# Roadway Plans\_V1.pdf Markup Summary

# CLEARWAY FILING NO. 2, LOT 5

# CONSTRUCTION PLANS

**STORM 6 STA 0+93.19 TO STA 1+61.31**

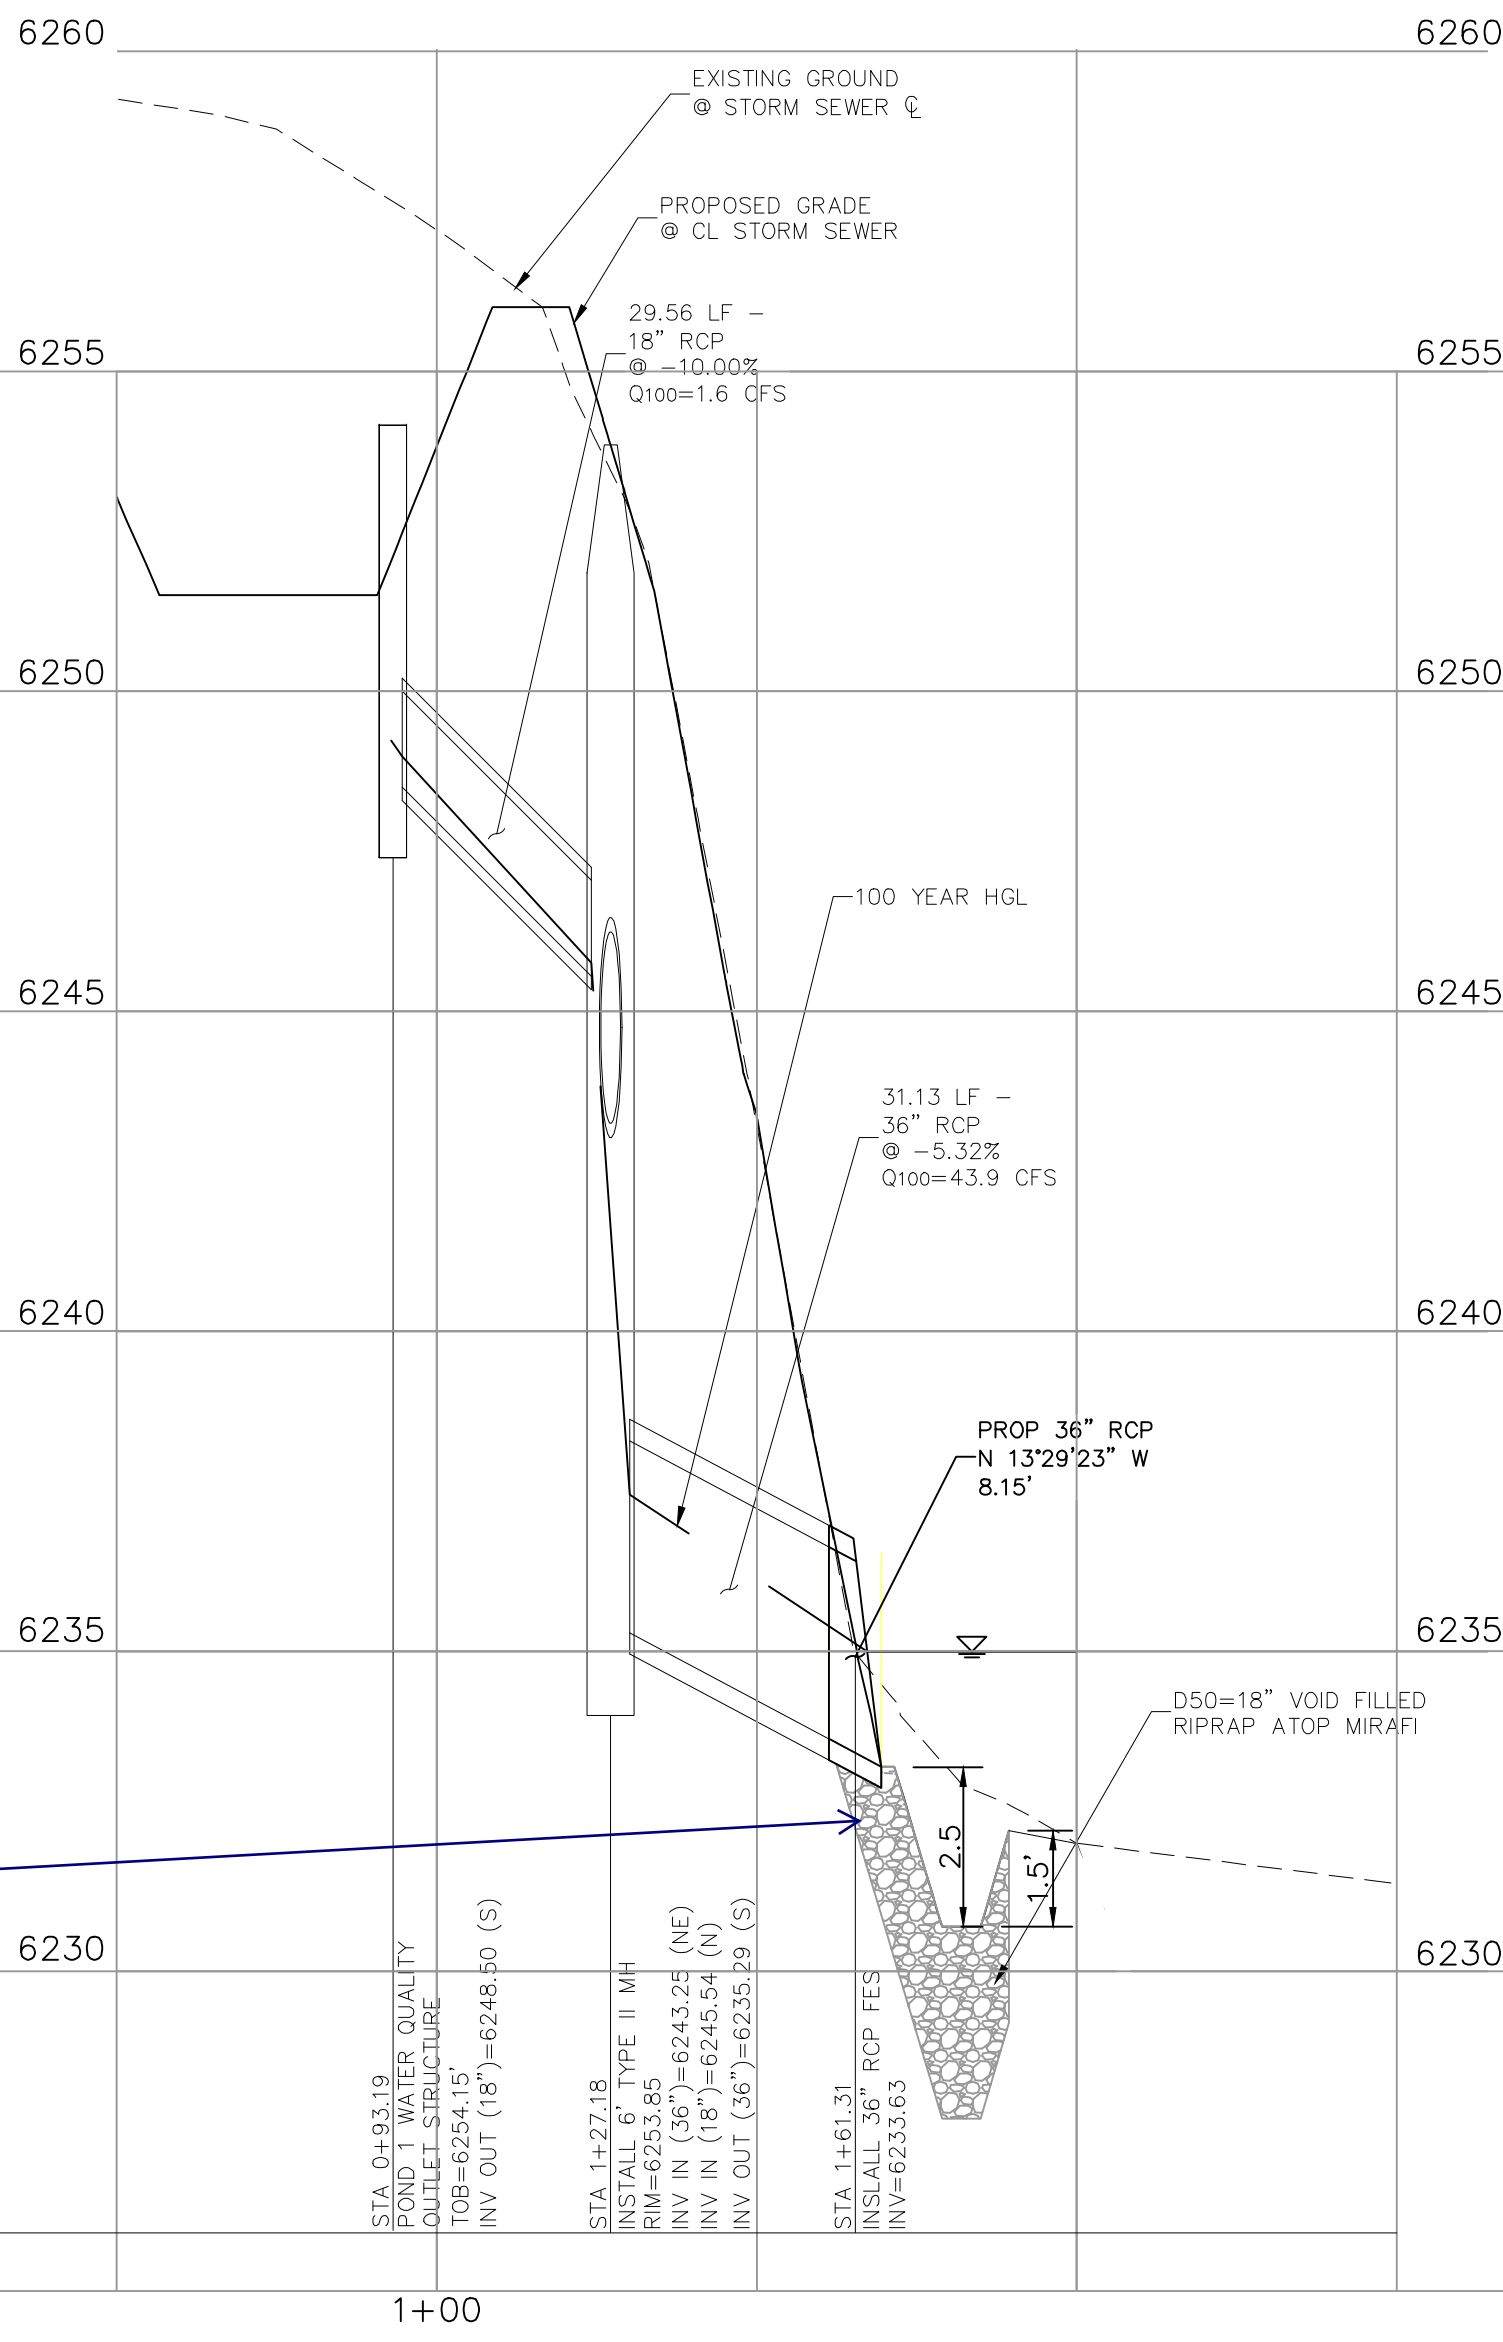
Show HGL lines on the profiles.

18" identified on the drainage plan. Revise accordingly.

identify the cut-off wall indicated in the GEC plan

clarify if there is a difference between soil filled and void filled riprap
